Response to ExA's Second Written Questions (ExQ2)

This document sets out the response to the Examining Authority (ExA)'s Second Written Questions and requests for information (ExQ2) by Cambridgeshire County Council (**CCC**) and Fenland District Council (**FDC**) (together, **the Councils**). The table below sets out the topic, question number and CCC / FDC's response.

- Notes:
1. Proposed visibility based on New Bridge Lane being subject to a revised 30mph speed limit.
  2. New street lighting has been provided on an indicative basis (at 30m intervals and at conflict areas) and will require detailed design and assessment.

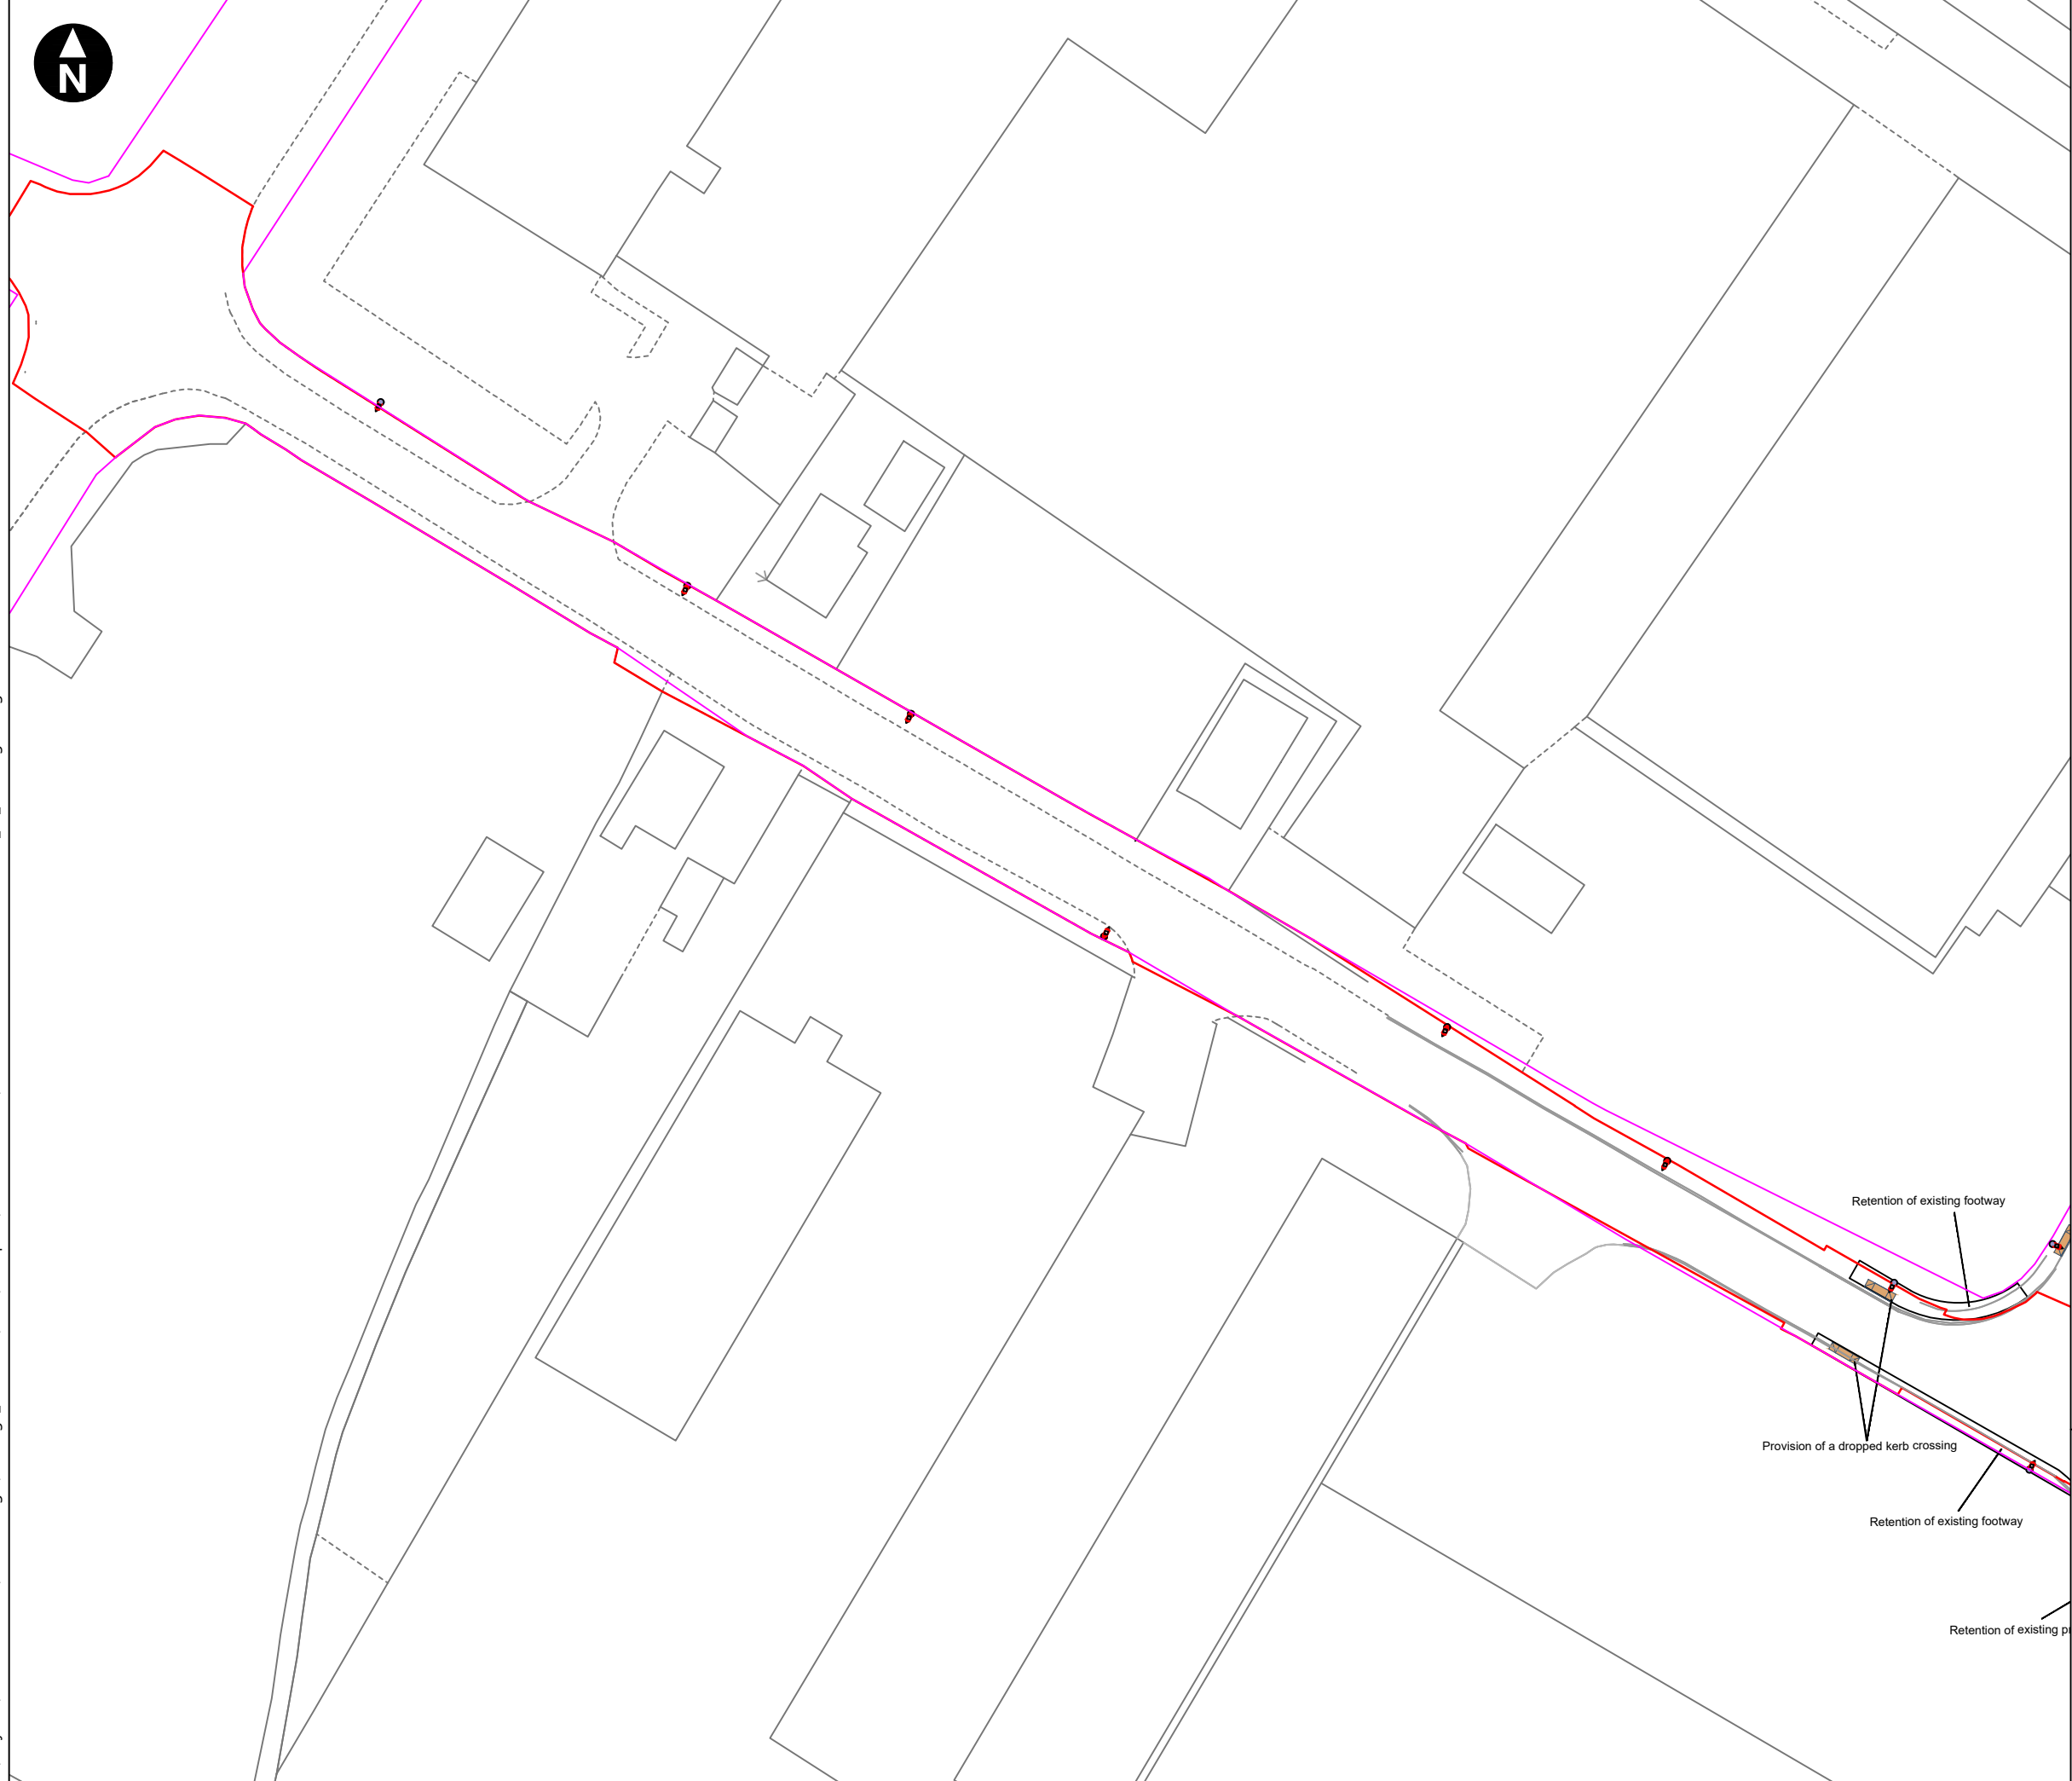
Draft Development Consent Order			
DCO.2.1	Cambs CC	<p>Action IHS2-12 [EV-032] asked for the Applicant to consider current drafting of Requirement 7 of Schedule 2 and to provide further explicit reference within the requirement of the works proposed and the approved details, in line with Cambs CC's comments.</p> <p>In its response to IHS2-15 [REP3-038], the Applicant stated that the amendments had been made to address this issue in the dDCO [REP3-006]. Can Cambs CC please confirm that it is content that the amendments as drafted address their concerns on this point?</p>	<p>CCC can confirm it is content with the amendments to Requirement 7 of Schedule 2.</p>
DCO.2.2	Applicant Cambs CC	<p>In response to action ISH2-13 [REP3-038], the Applicant has stated that prior to Deadline 3, it met CCC to discuss highway matters on the 13 April 2023 and is liaising with them regarding predevelopment condition surveys and s278 obligations.</p> <p>Can the Applicant and Cambs CC please update the ExA on any developments following from Deadline 3?</p>	<p>The Applicant and representatives of CCC have met on more than one occasion since ISH2. The Applicant has engaged CCC on the matter of s278 obligations and these are currently under negotiation. CCC's comments on the Applicant's draft s278 terms were returned to the Applicant on 31 May.</p> <p>CCC still awaits further engagement on the matter of pre-development condition surveys, but would note that the most recently published version of the outline CTMP [REP4-007] does not fully satisfy the concerns previously raised.</p>

<p>permission is in the gift only of Network Rail, this is a simple request that would bestow a significant benefit for local communities.</p> <p>The signage and any agreement should be in place upon completion of the proposed works to the crossing as part of the New Bridge Lane improvement works, prior to the commencement of operation.</p> <p>4) A S106 Legacy Fund has also been discussed with the Applicant to help address CCC's concerns over planning policy requirements. Negotiations are ongoing.</p> <p>With regard to NPS EN-1 para 4.1.8, the Councils understand that, had this guidance been available to the Applicant two years ago when they were drafting their proposal, they would have been able to take it into account for implementing mitigation along the lines proposed at element 1 of the Councils' list. However, unfortunately, the Councils understand that the draft DCO is now too advanced for it to be amended to accommodate this provision. This would have been the Councils' preferred approach, as it would create greater certainty and would significantly reduce the burden on the Councils involved in delivering the NMU enhancements. The problem faced is that any land that might be put forward for BNG or over which public rights might be created will all be outside the Order Limits, which would require a material change to the DCO. The Applicant would also need time to approach any third parties concerned. If this option is not available to the Applicant, it is critical that the mitigation package is securely devised and that it includes recovery of all the Councils' costs incurred in implementing it.</p> <p>The Councils would like to see the Applicant committed to making efforts to include private sites such as those suggested</p>

Figure 8.1 Air quality survey monitoring locations , ES Chapter 8: Air Quality

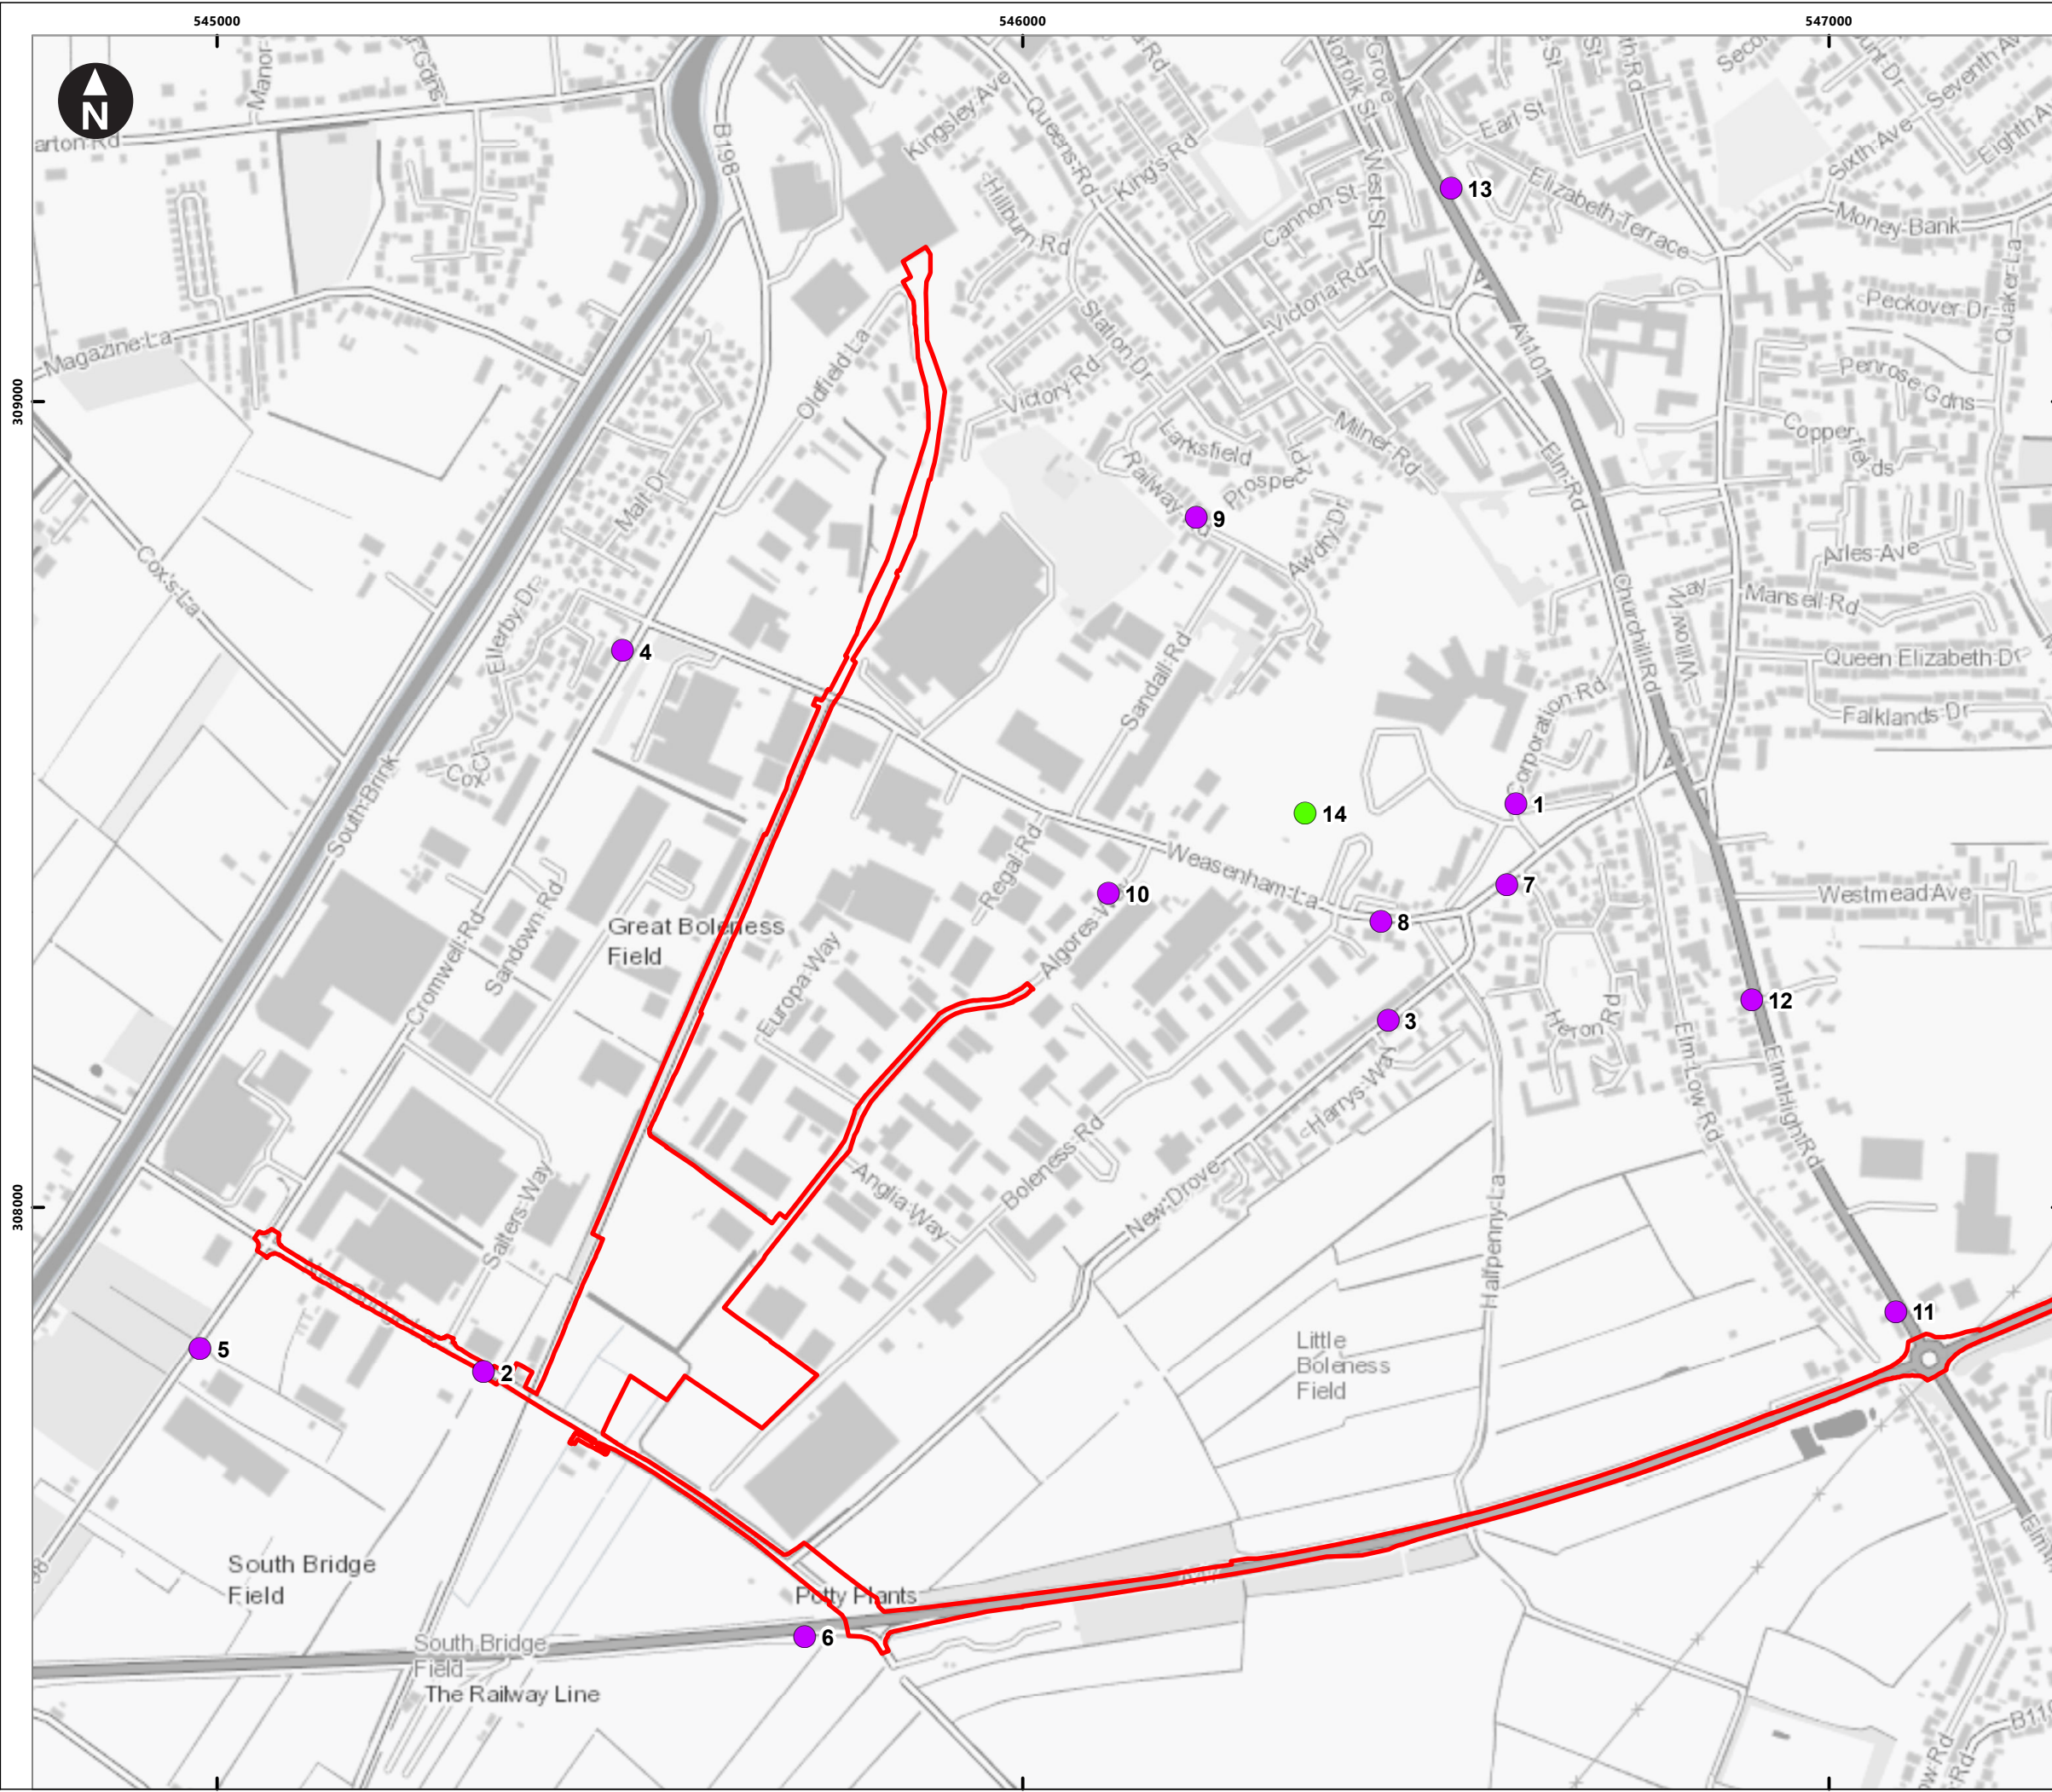
AQHH.2.2	Applicant Fenland DC	<p>The Applicant's Outline Local Air Quality Monitoring Strategy (LAQMS) [REP3-034] and [REP3-035] states that in para 2.1.4 that the date collected will be published quarterly on the Applicant's website and, if requested, issued to the relevant planning authority. In goes on to say, in para. 2.1.5 that the Applicant agrees to share by remote secure access the information collected by the LAQMS.</p> <p>Does Fenland DC agree with the wording included here?</p>	<p>FDC agrees with the wording. A concern was previously raised regarding the frequency of monitoring and publishing data. The Applicant has addressed this with the addition of paragraph 2.1.7 in the latest version of the Outline LAQMS [REP4-016] with a commitment to report and investigate exceedances.</p>
----------	-------------------------	---	--
